Please upload onto Ocella the email below and the attached revised plans and amended Flood Risk Assessment from the **applicant's drainage engineers** for planning application **A/76/20/PL** relating to Dappers Lane, Angmering.

Subject: RE: Dappers Lane A/76/20/PL

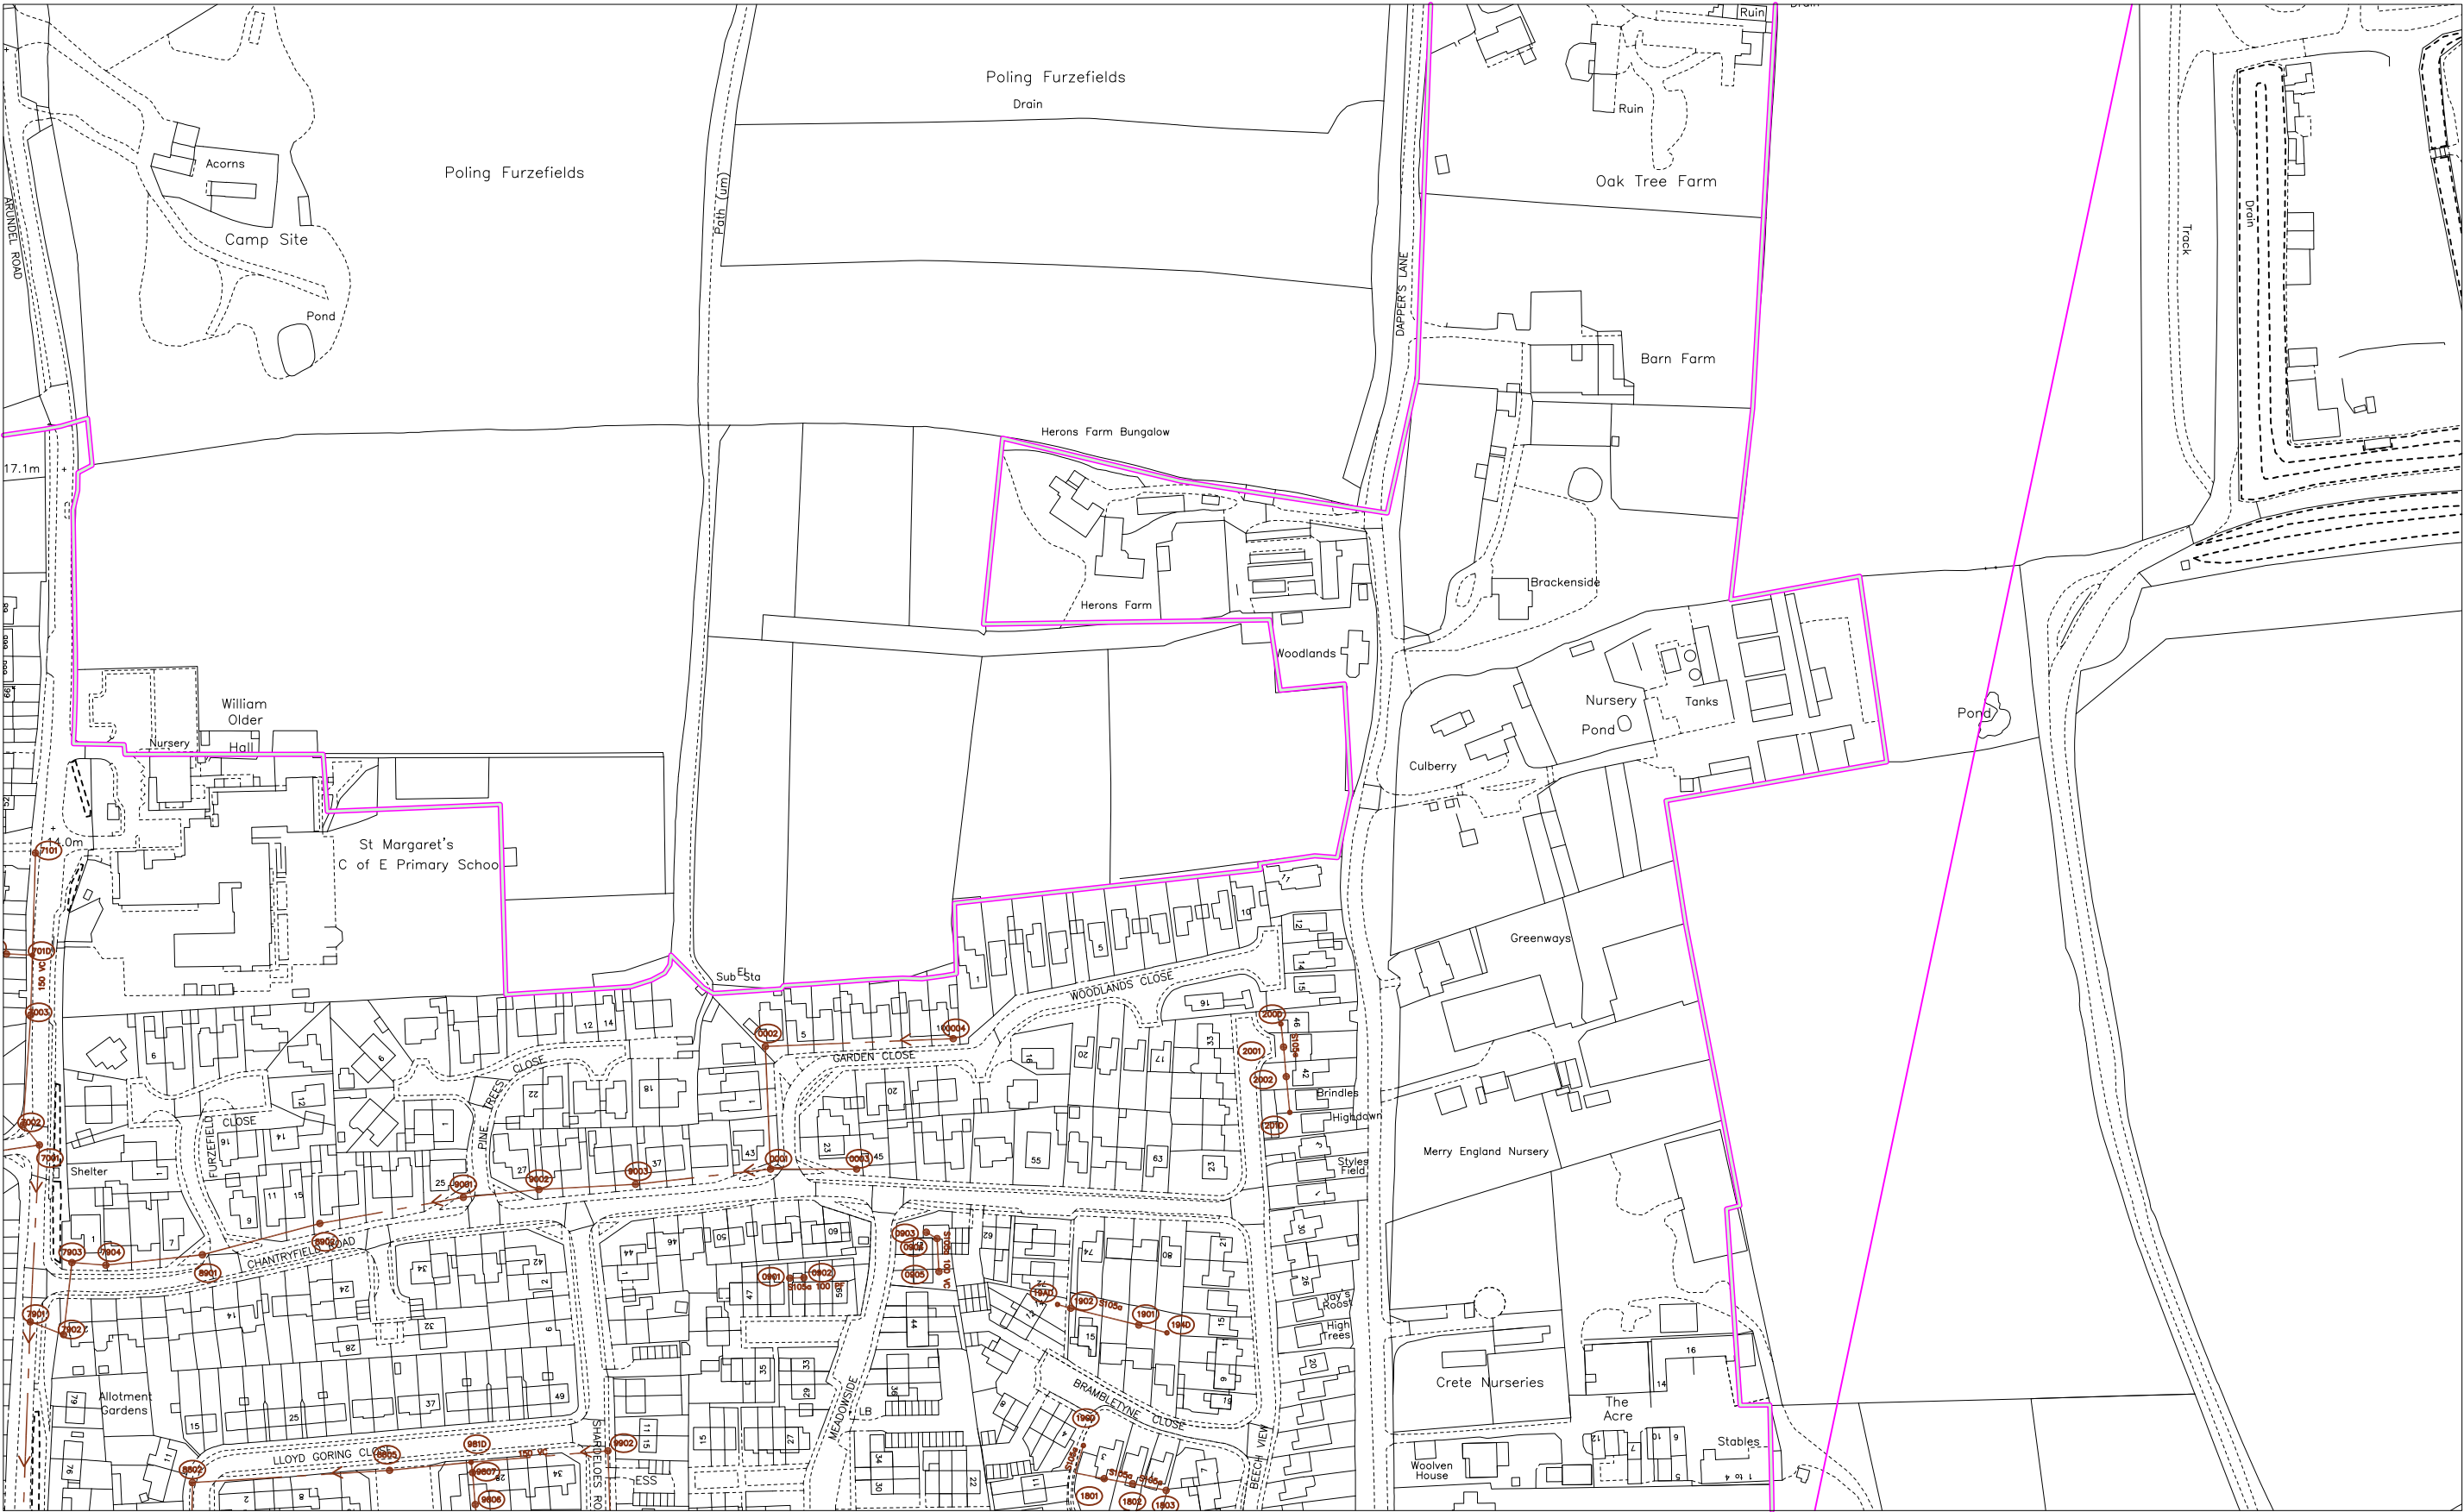
I attach the updated FRA in view of this change, along with the drawings contained within as well as in addition to which I hope alleviate your remaining concerns. Drawing PL500A demonstrates the indicative pond sections with the 3.00m easement between the two features (pond and ditch).

2. Cross sections of attenuation basin, detailing offset of basin to surrounding features, including adjacent ordinary watercourse. An unobstructed 3m buffer should be provided around the attenuation basin. There is a buffer around the pond of at least 3.00m, with the exception of to the south of the pond where it is slightly reduced owing to the re-grading works associated with the watercourse. This has not been detailed out at present, and is a point for detailed design. It is demonstrated, however, that the pond can be maintained with the buffer that is provided in all other areas. *See comment to point 5 below. The screen shot below has been provided by Rob with the following comment; 'The outer 'circle' shows the 3 metre offset at the top of the bank (of the pond). This coincides with the 3 metre maintenance strip for the culvert along the southern edge.'*

5. evidence that a 3m buffer is provided throughout the site to the southern watercourse (N.B. 3m is measured from the top of bank of watercourse). As mentioned above, where the watercourse passes adjacent to the pond along the southern boundary, it is not possible to provide a 3.00m buffer – it is slightly reduced here. As we move past the pond (to the west towards the outfall location where the culvert is located) it opens back up again. Essentially, we have a 'pinch point' by the pond. *There must be a 3m buffer between the basin and top of bank of the watercourse to facilitate maintenance of both the watercourse and pond. In addition, it is evident that plot 7 (house and fence line) is located on the top of bank of the watercourse. This must be set back 3m. This is being dealt with as part of a redesign and plot 7 will be set back. Please also refer to my comment above in relation to 2.*

Hope all is well, it's been a little while since we last spoke concerning Dappers Lane. The good news is we now have the amended layout with the 'skinnier' pond which has been extended out to the west as previously discussed. We now also have the 3.00m maintenance strip between the pond and the improved ditch along the southern boundary which was required as per the outstanding point(s) in relation to your holding objection.
